Online Comment

Application H08-0218-20
Location Site Adj. Silverdene Boston Road Gosberton PE11 4NR
Proposal Residential Development of 18 Dwellings - outline approval H08-0866-18

Name Angela Doherty
Address Housing Strategy

Date Submitted 17-06-20
For/Against Comments

Drawing Number:	Rev:
A1435 - 19	A

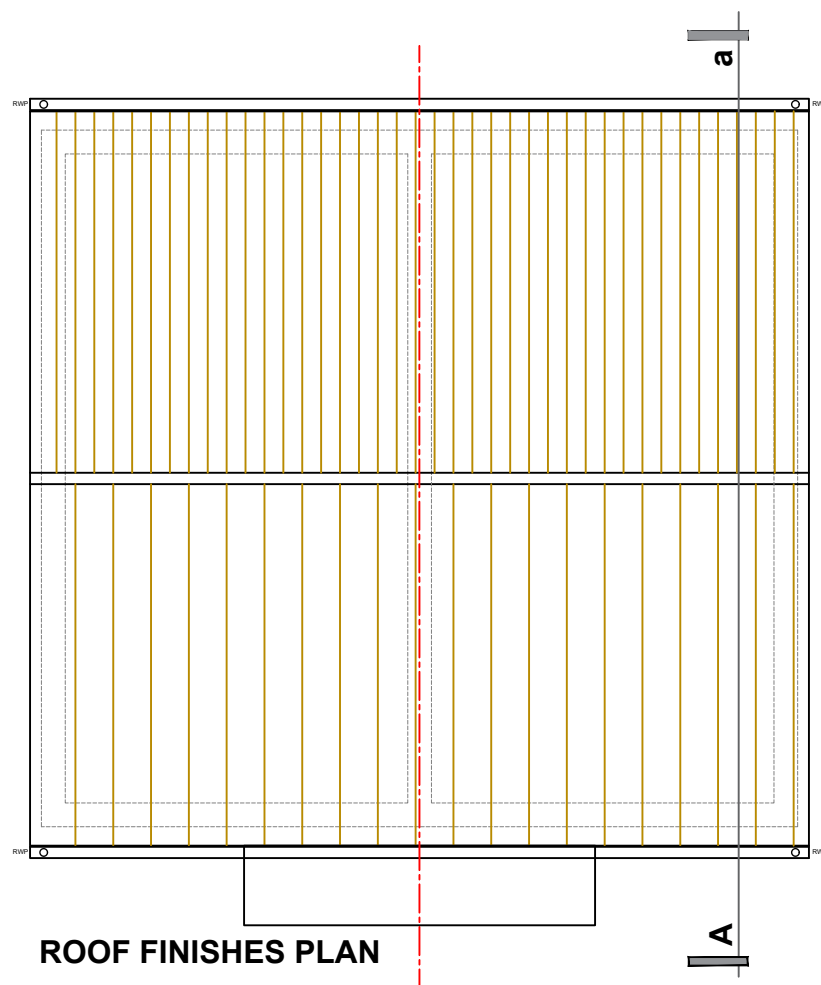
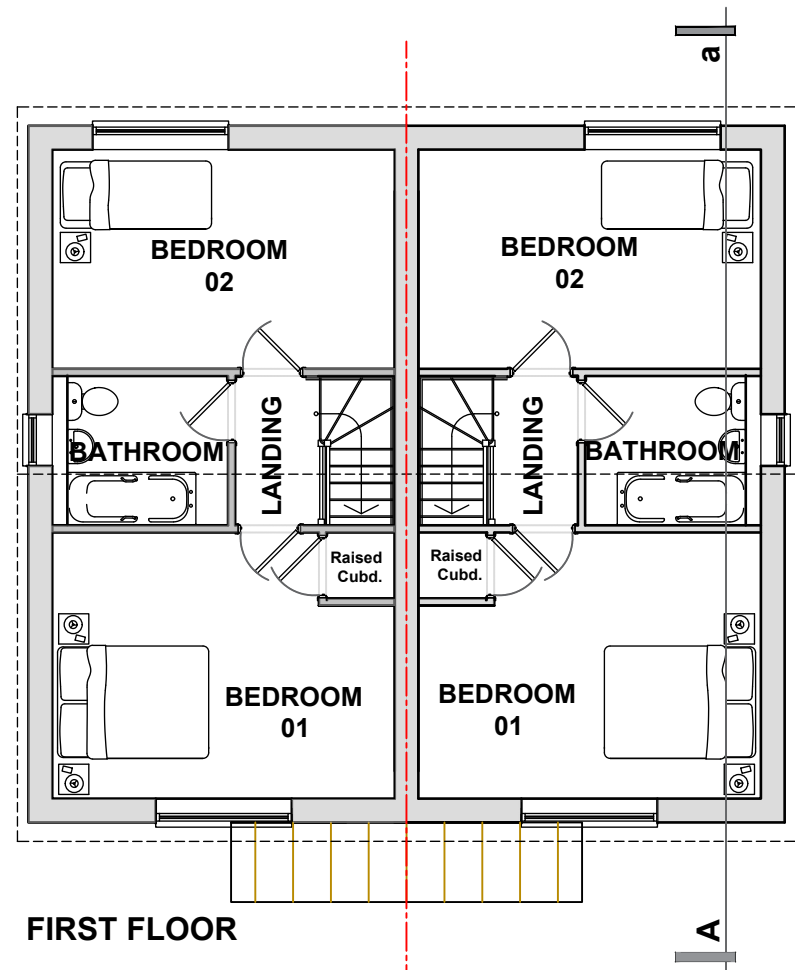
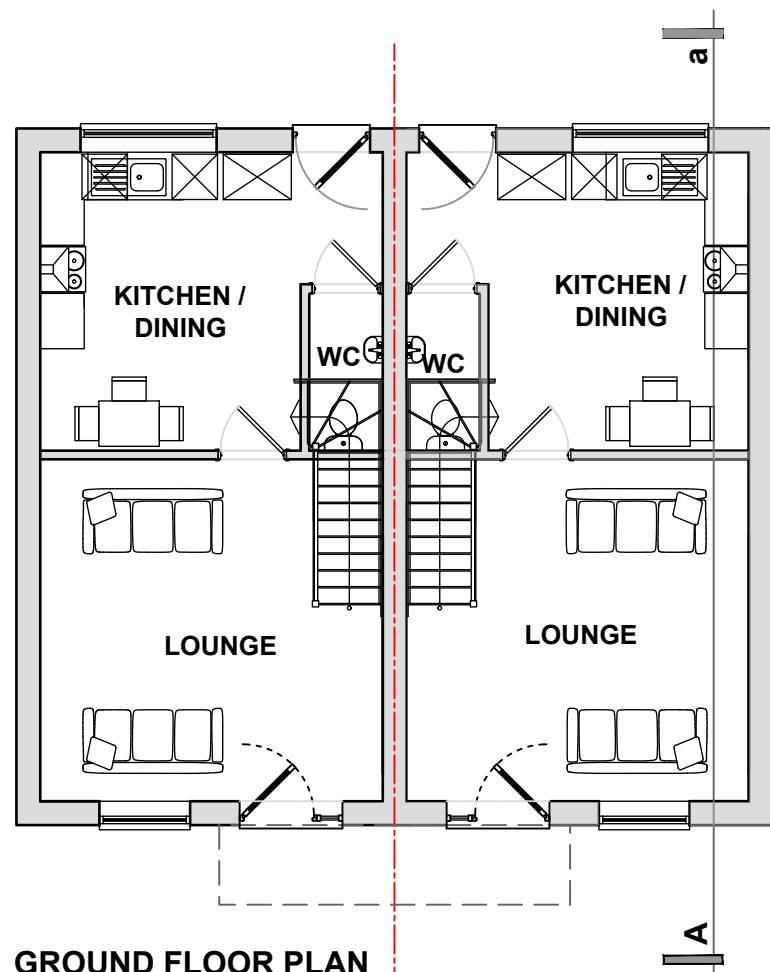
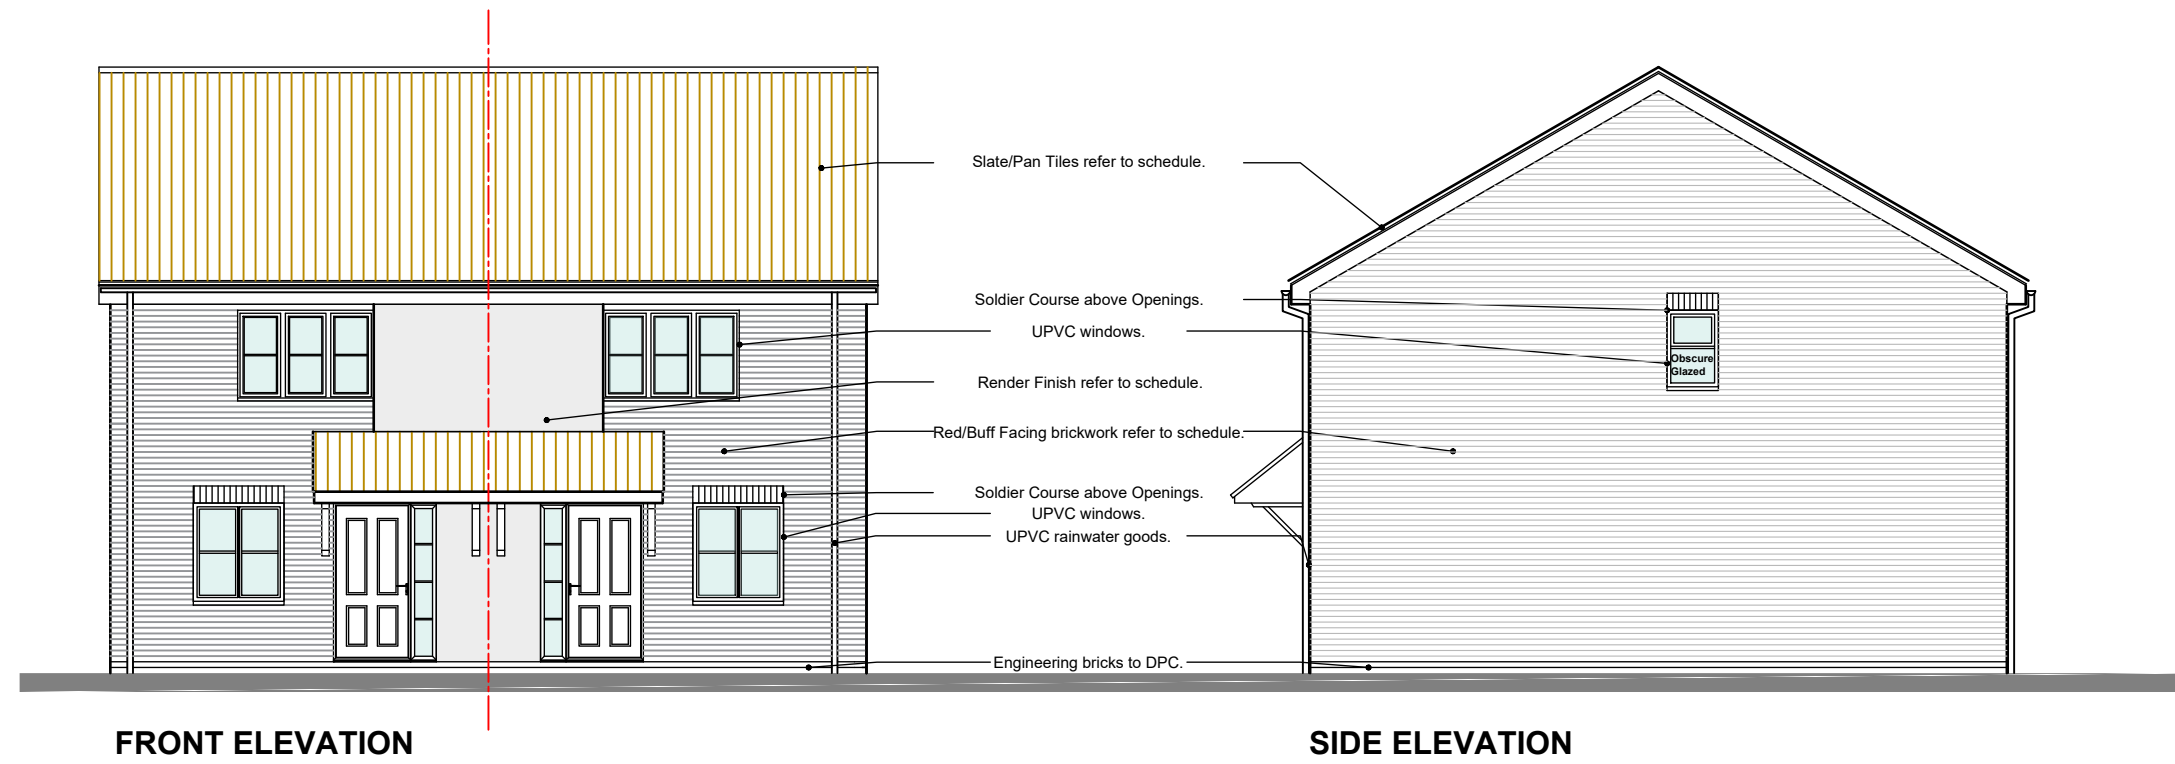
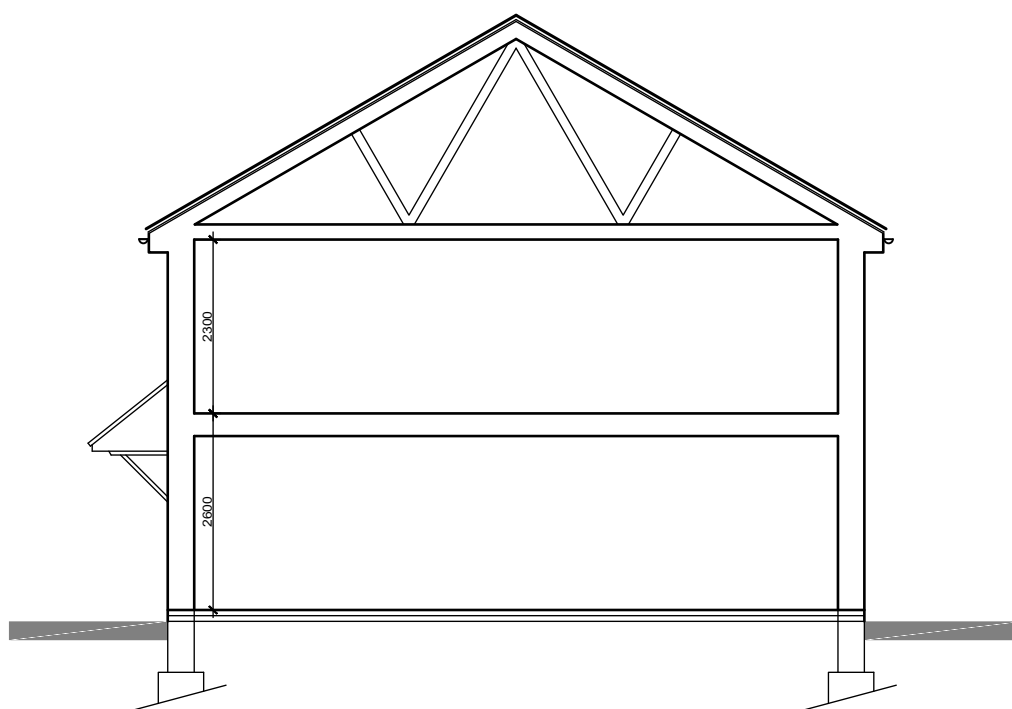
Detailed within the Affordable Housing submission for this application, the developer is proposing to deliver 5 affordable homes, with 3 x 2 bedroom houses for Affordable Rent and 2 x 2 bed houses for Intermediate Housing for Sale. The percentage of affordable housing proposed and the tenure split proposed broadly accords with Policies 18 of the South East Lincolnshire Local Plan. However, Policy 17 encourages a range of house types and sizes to meet a range of needs. To accord more closely with this Policy the developer should reconsider amending the Affordable Rented mix to deliver 2 x 1 bed houses and 1 x 2 bed house.

It is unclear the internal floor space of the affordable homes. As per the wording within the South East Lincolnshire Local Plan it would be preferable for the homes to be built to the 'Nationally Described Space Standards'. Ideally the affordable housing should be spread proportionately across the scheme to enable a mixed and sustainable community.
